Your ref 2023/62/92966/E  
Our ref J0061352

## **LAND TO THE REAR OF 271, CLIFFE LANE, GOMERSAL APPLICATION REF: 2023/62/92966/E**

We write to submit revised information in relation to the proposed development at land to the rear of 271, Cliffe Lane, Gomersal, Application Ref; 2023/62/929666/E in response to the comments Yorkshire Water, the Lead Local Flood Authority and the Waste Strategy Team.

DRAWING NO.	1694-107	REVISION	-
SCALE	1:100 @ A1	DATE	01.23
DRAWN BY	BC	CHECKED BY	JC

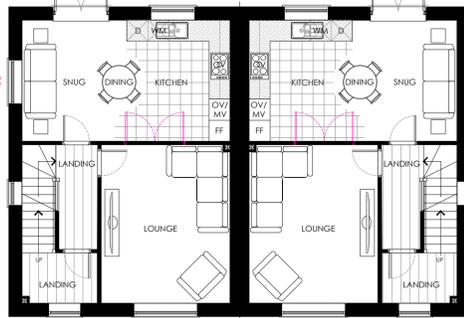
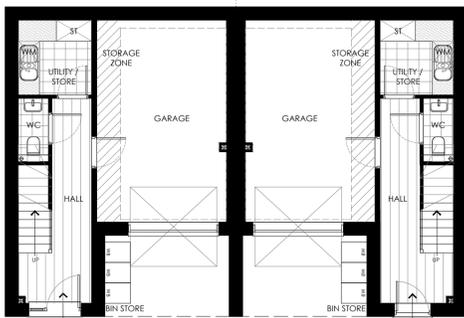
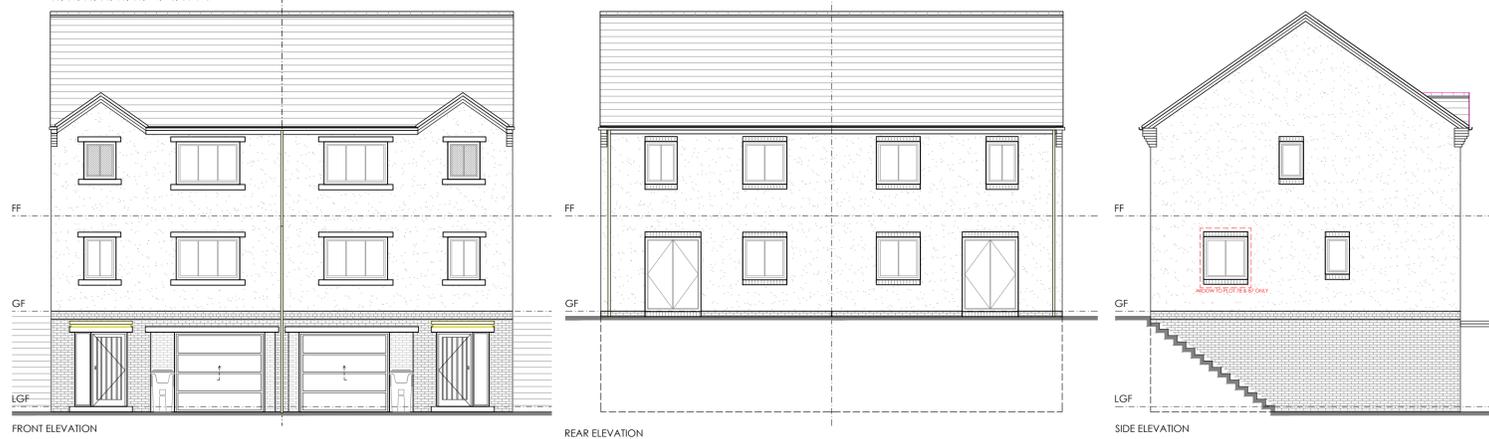
Plots 63-66, 75-79, 80, 85-88 and 94-97 are split level dwellings accommodating a recessed garage on the ground to accommodate bin store as rear storage is not possible. Drawings 1694 – 107C, 108B and 109C display this.
